H2Teesside Project

The H2 Teesside Order

Document Reference: 8.2 Errata Report

Date: August 2024

**FIGURE NUMBER**  
Figure 12-4 (Sheet 12 of 59)

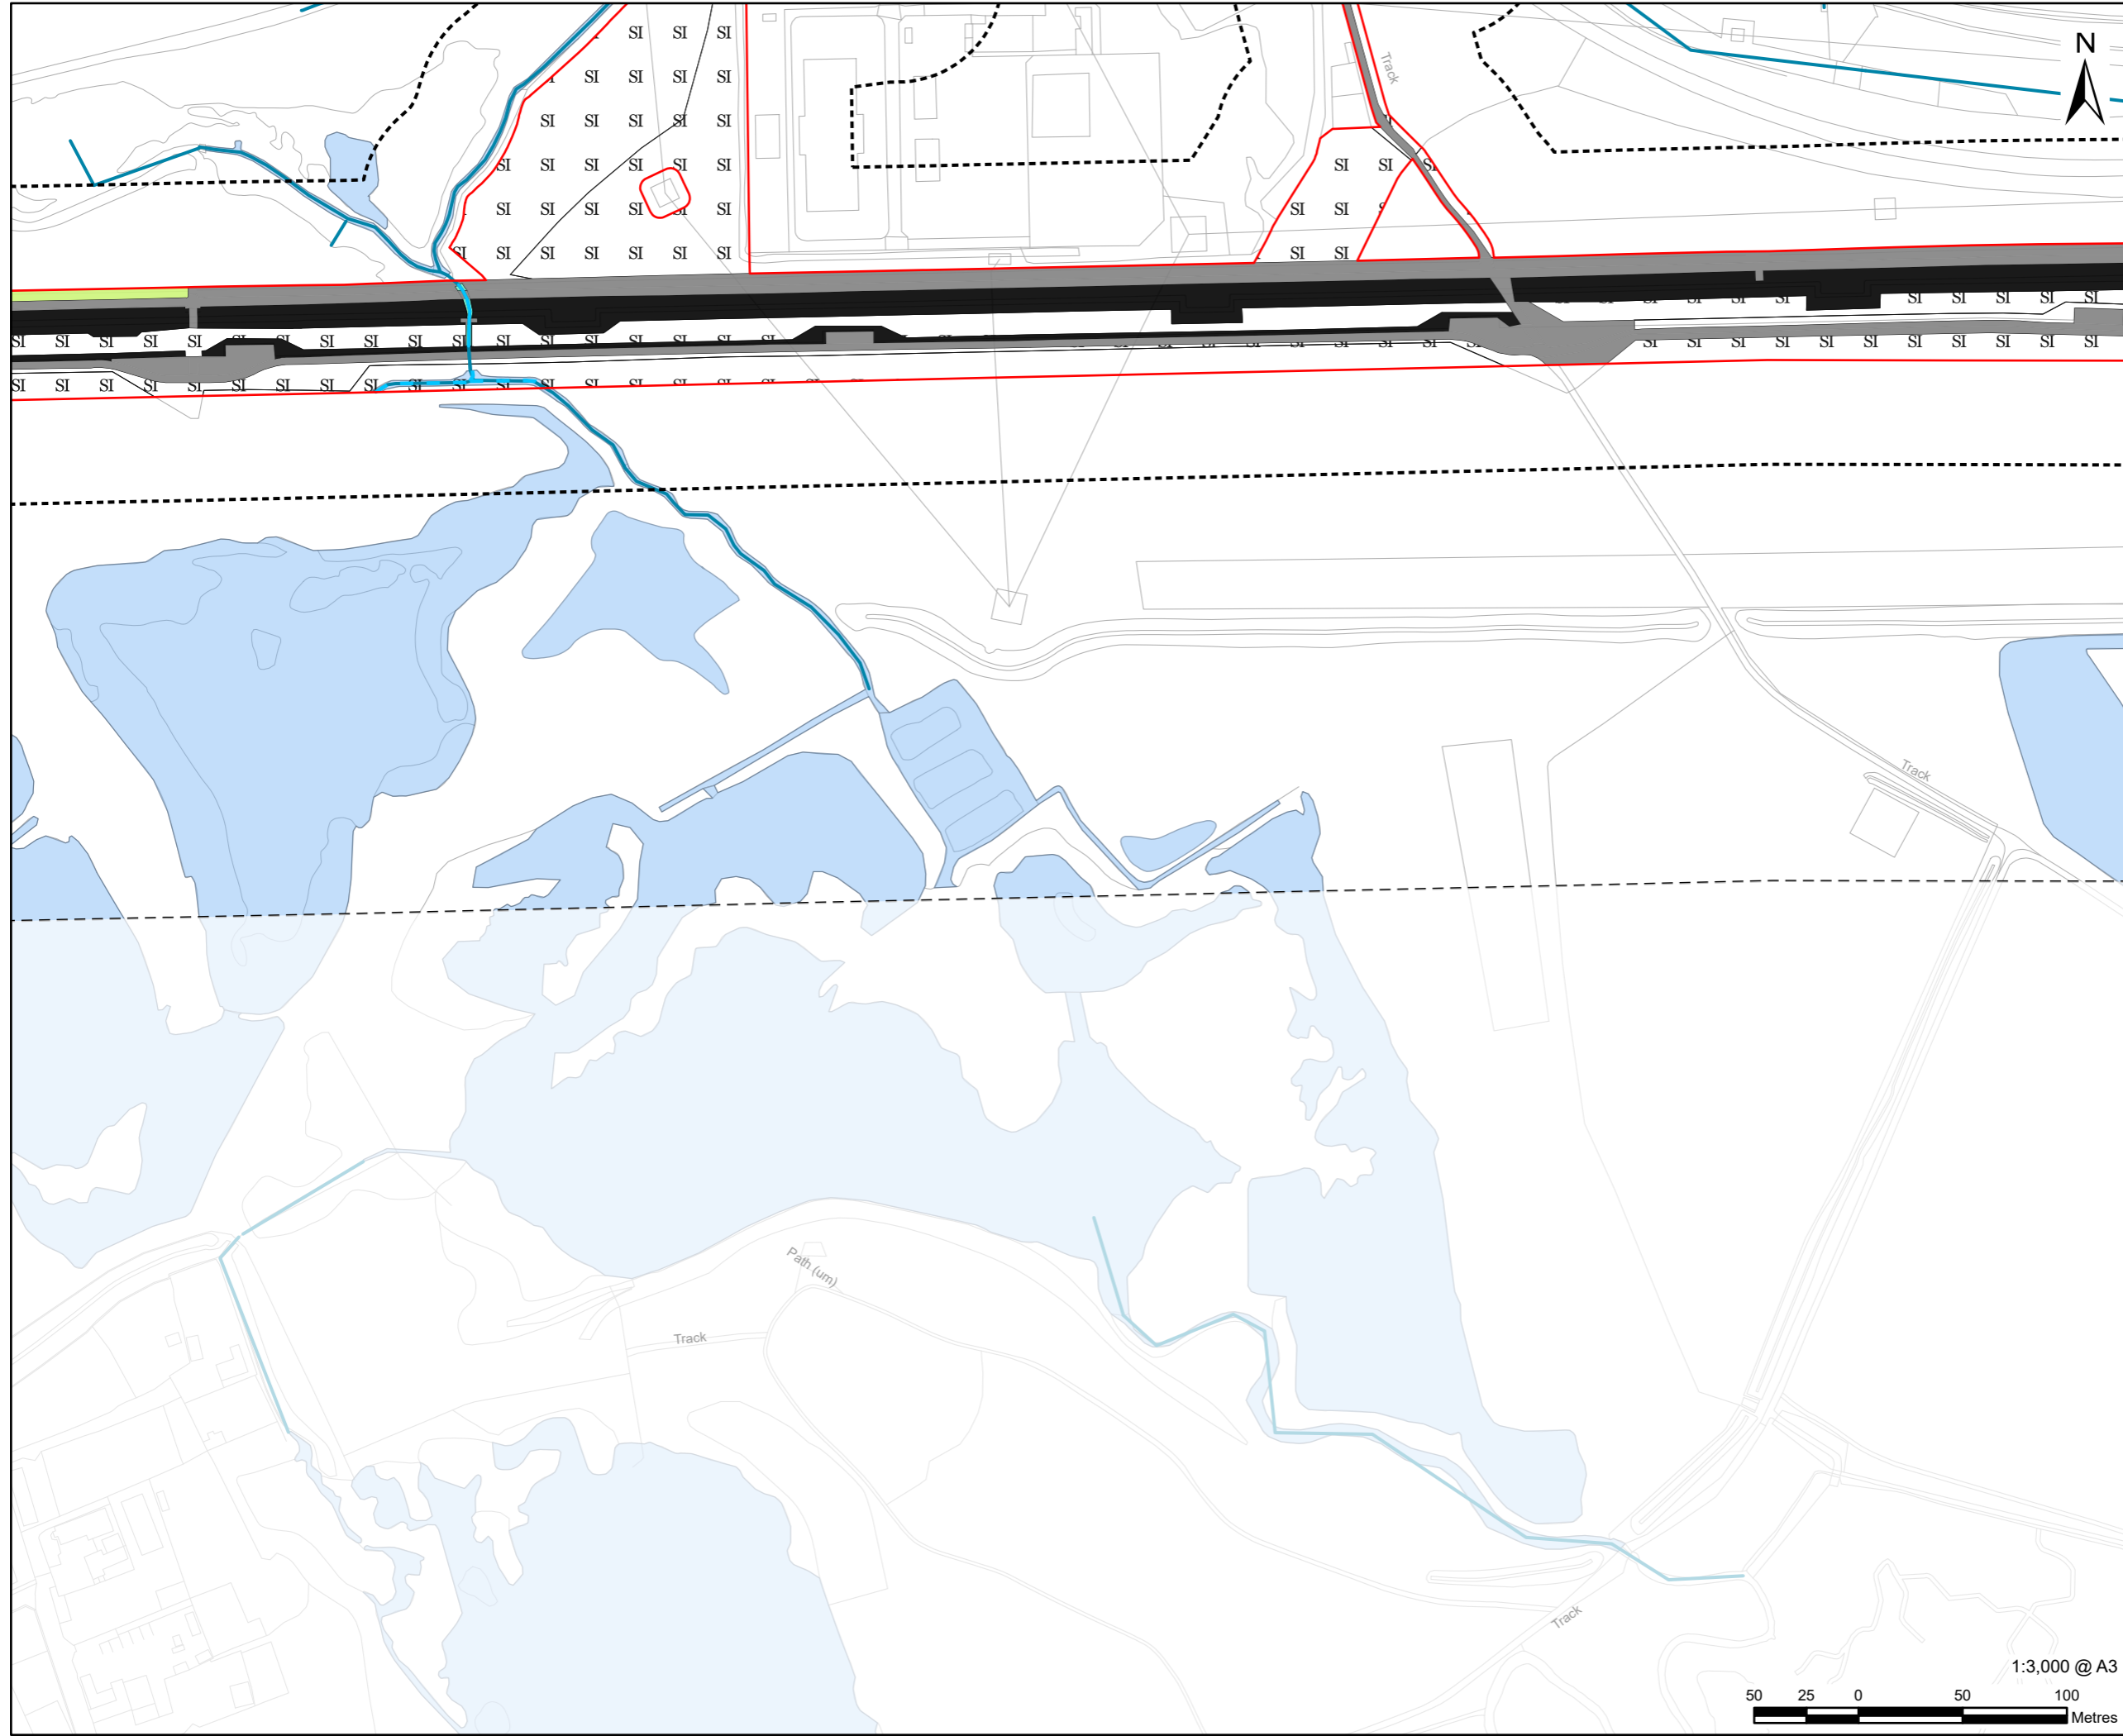
- 1.2.12 Updates have also been made to the Important Hedgerows to be Removed Plan [AS-010] and Sheet 5 only of ES Figure 12-4 [APP-148] and these are submitted alongside this report. The updates have beenmade to correct that an area previously reported as ruderal habitat should have been reported as important hedgerow. The Applicant confirms that this does not lead to any changes to the conclusions of the ES.
-
